From:**Sent:** Friday, February 23, 2024 3:51 PM**To:** DCAdmin <DC.Admin@kirklees.gov.uk>**Subject:** planning application number 2023/93797 - 14 New Road Kirkheaton

A few years back the plans were submitted, and we did iron out some concerns, however it appears that this is a different applicant, hence after reviewing the plans for the conversion of the "Liberal club" Kirkheaton, 14 New Road, HD5 0HP
We have a few concerns relating to the above as we live next door at 16 New Road.

North Elevation - 1:100

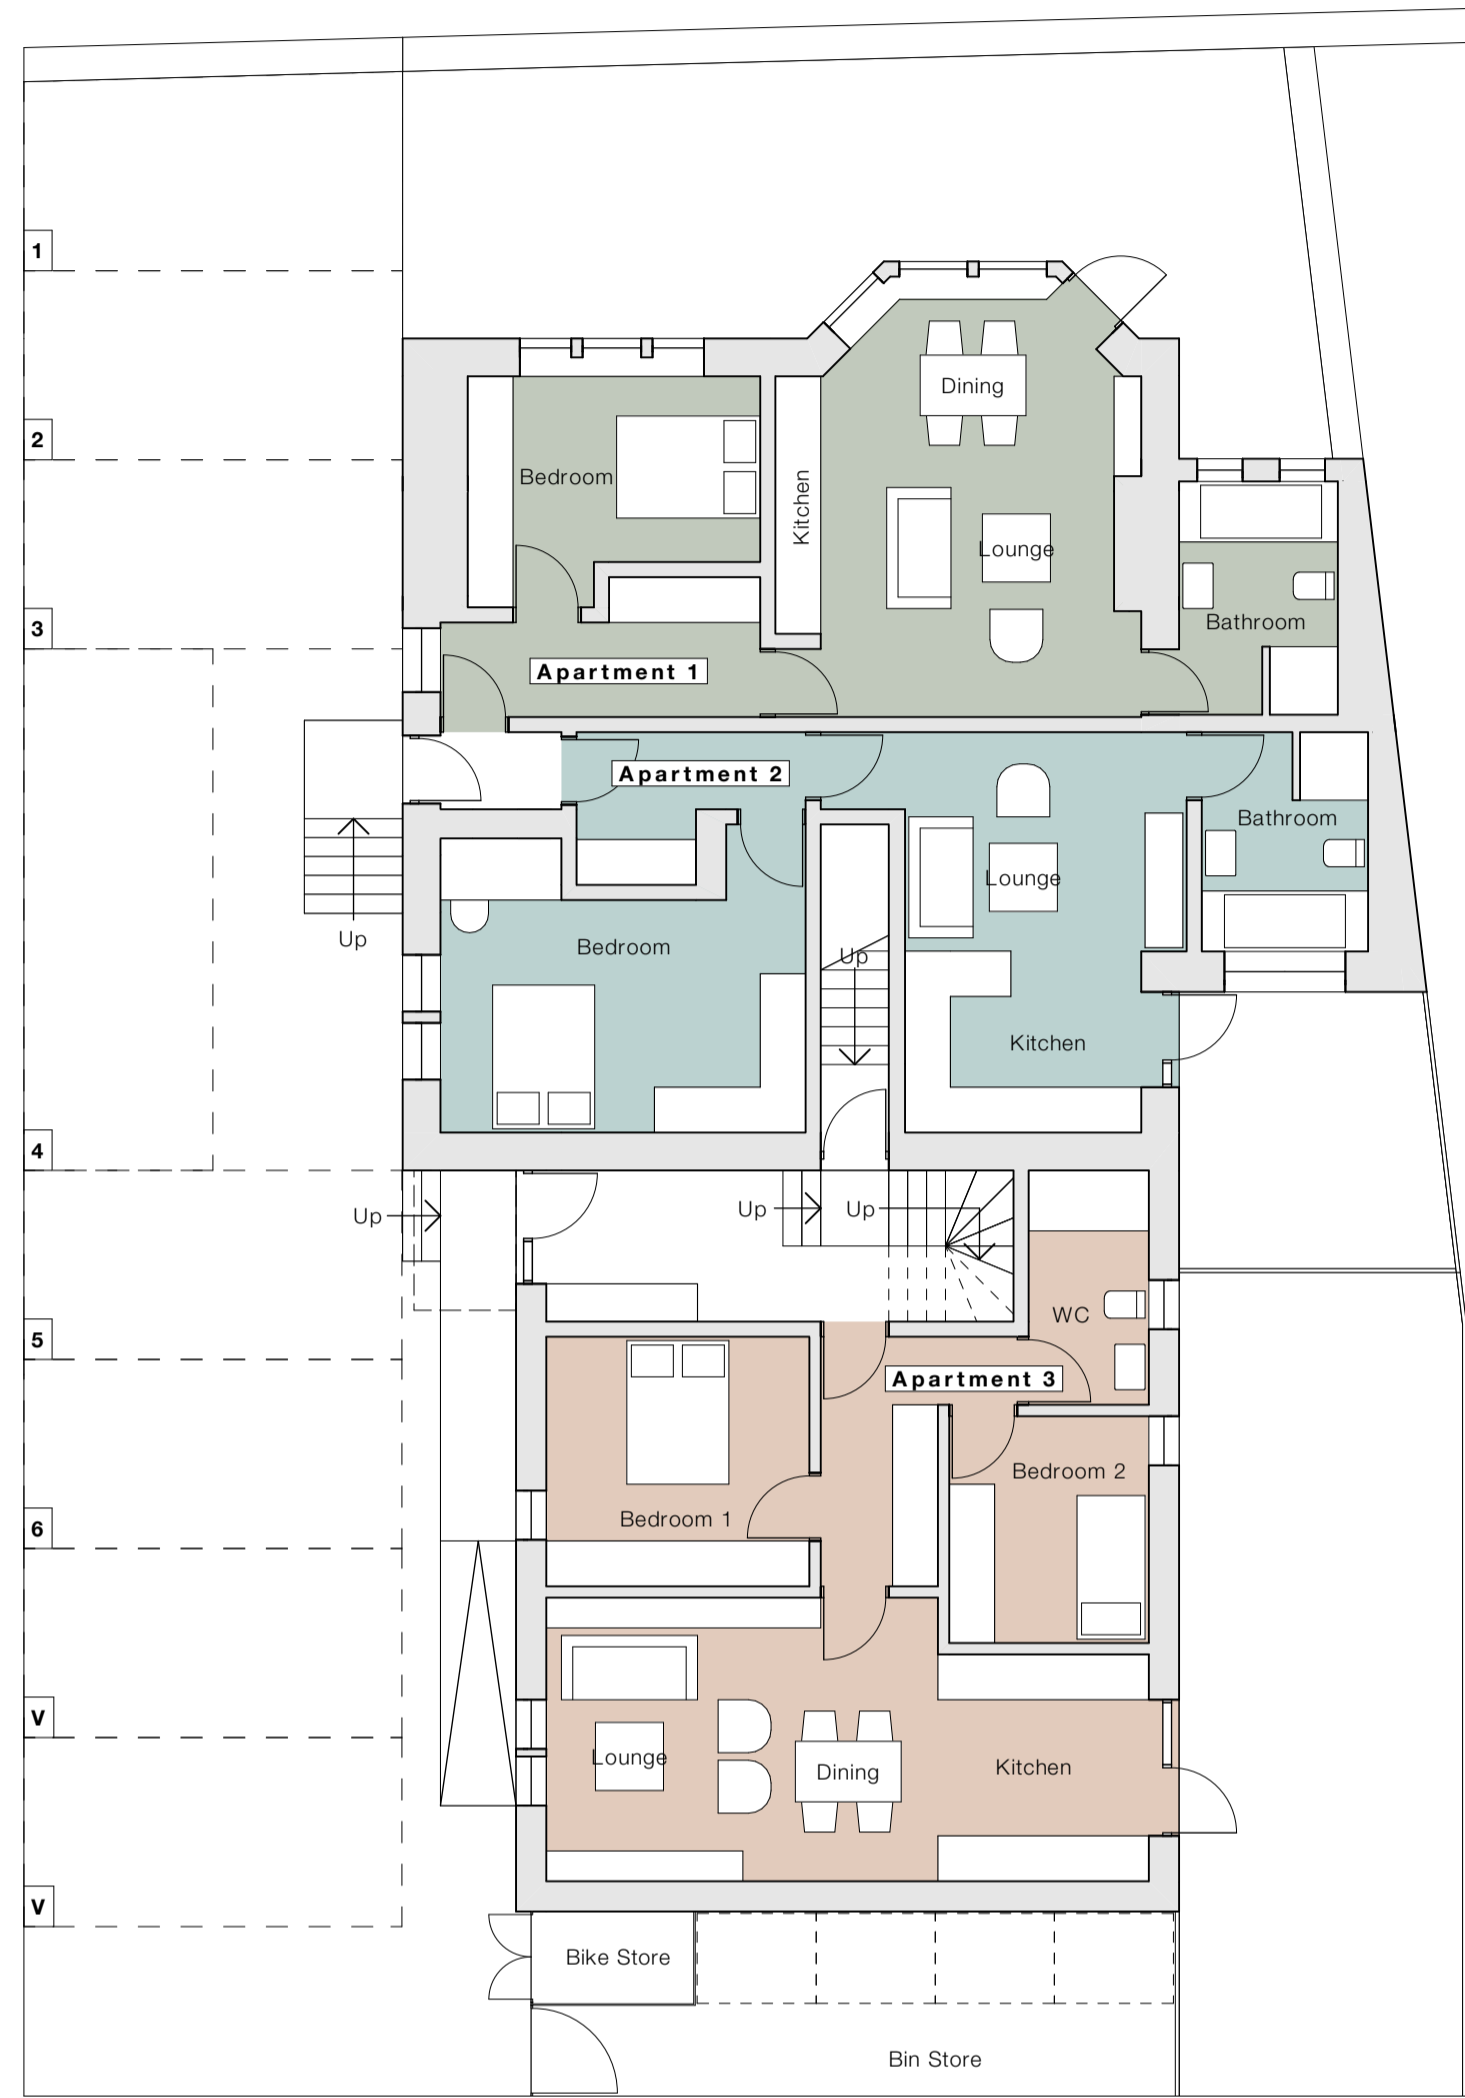
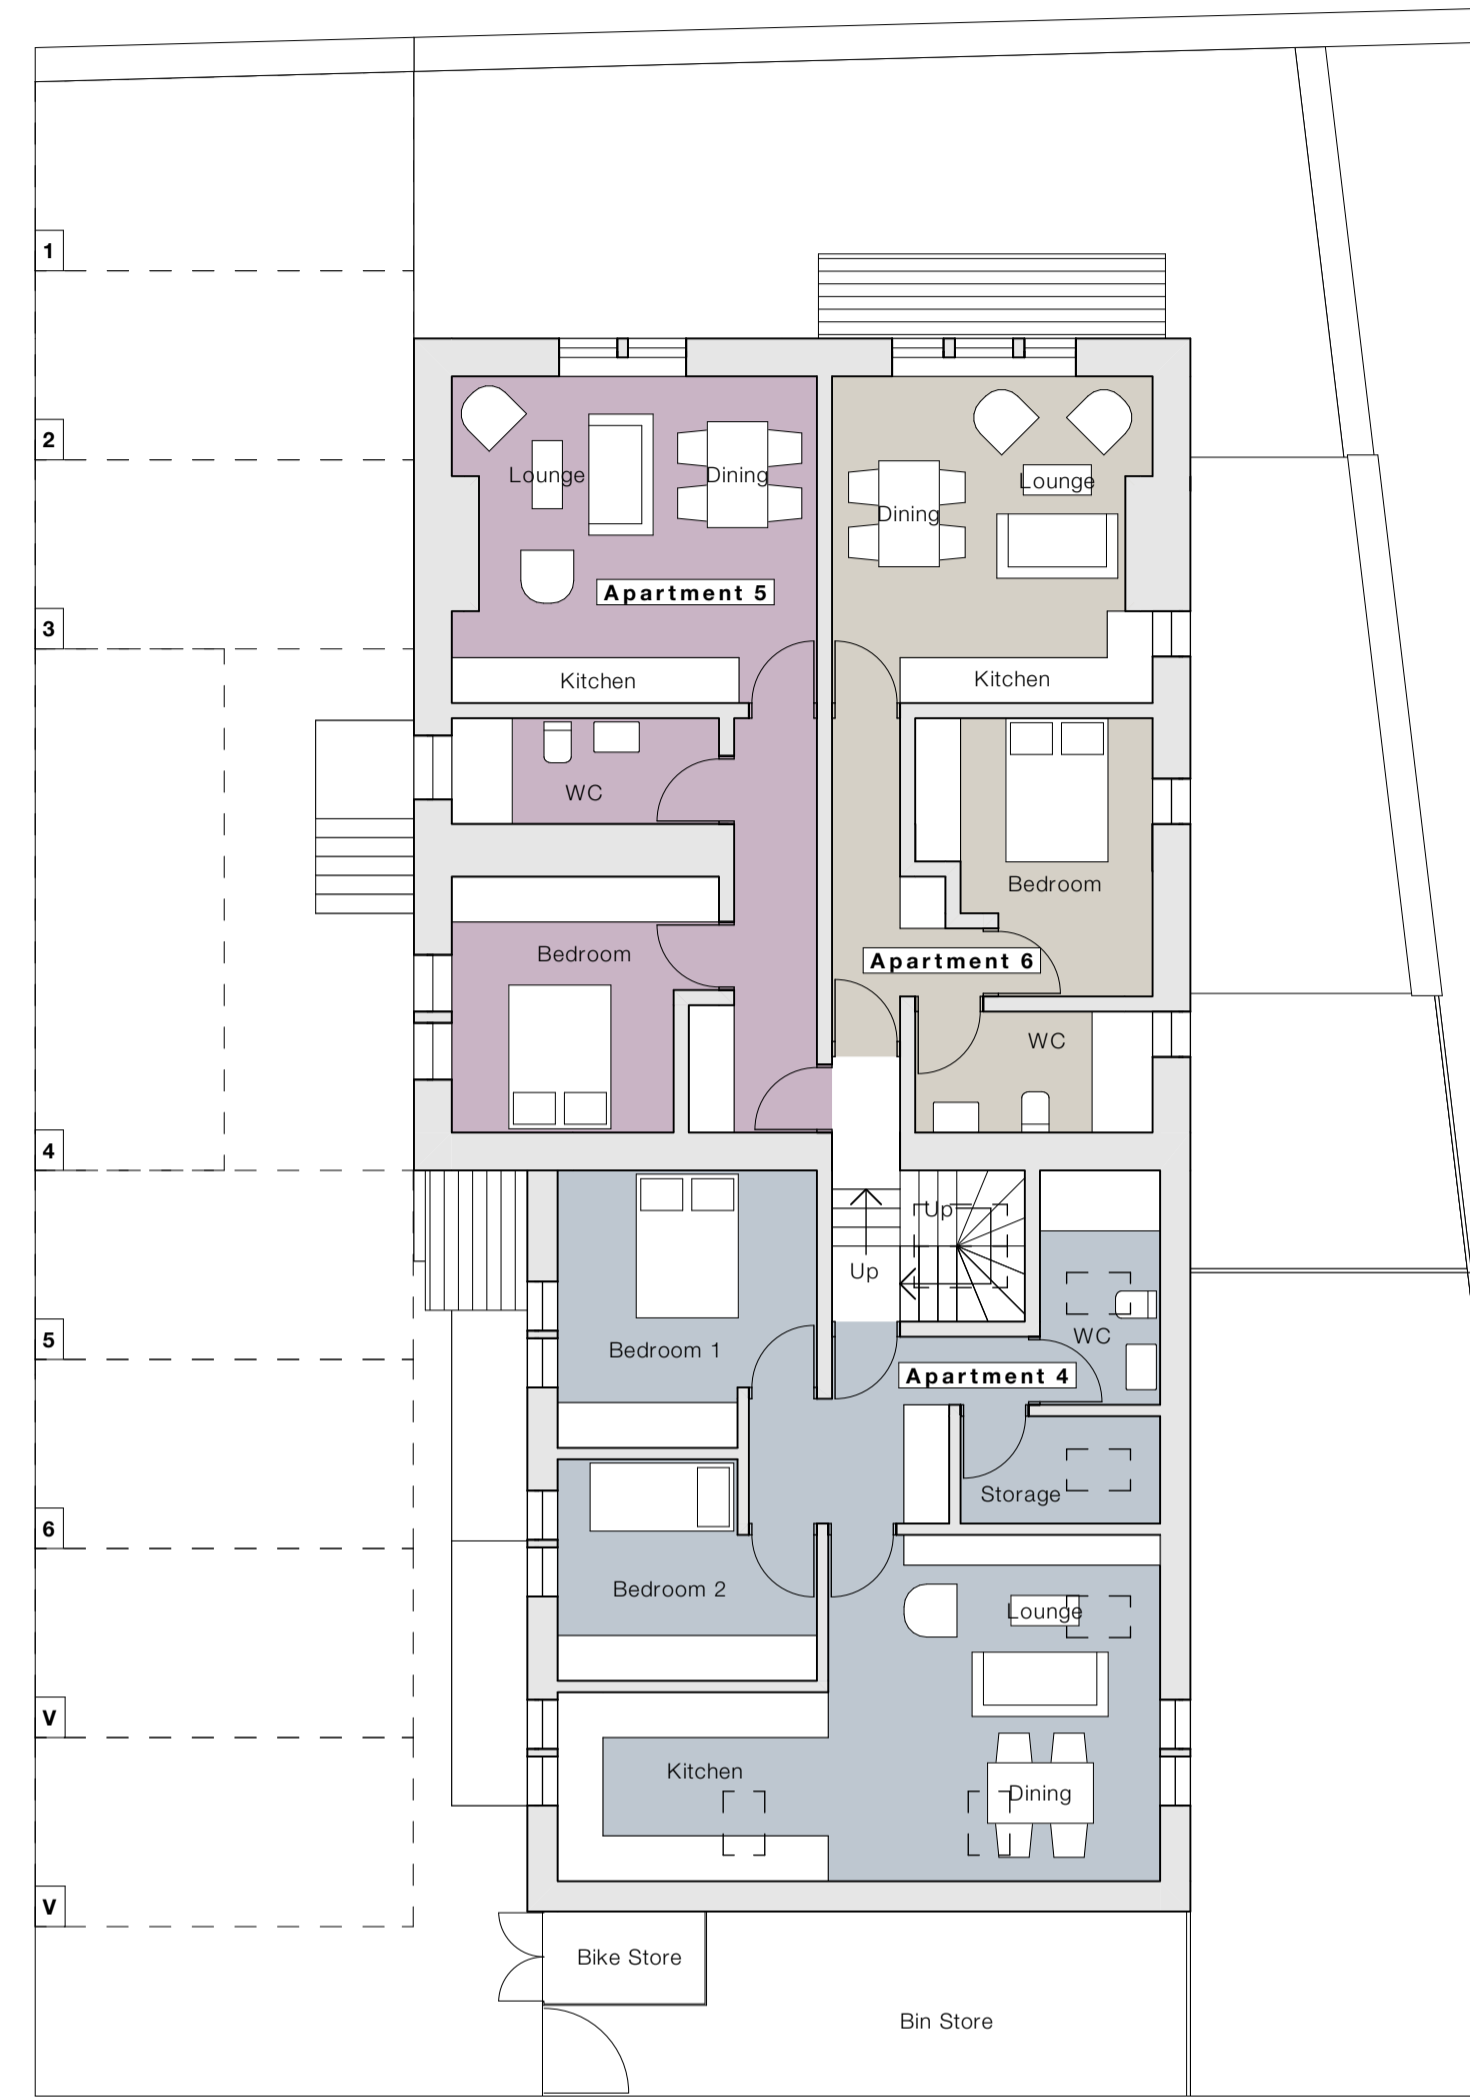
1. There are 3 windows on the North elevation which will directly look onto our house, We have never been overlooked before, so we are not happy about this.
2. There will be a lot of intrusion onto our rear garden with the demolition of the boundary wall, Will our garden be made good, following the building work?
3. Will there be a fence erected on the boundary, if so how high? As once again we do not want to be overlooked!
4. There is an existing fire escape which leads from the existing upper floor onto our property, hopefully this will be removed. When it was the Liberal club, we received rent from them for this being in our garden, as at one time our house was tied to the club for the residence of the stewards, and we honoured that agreement.
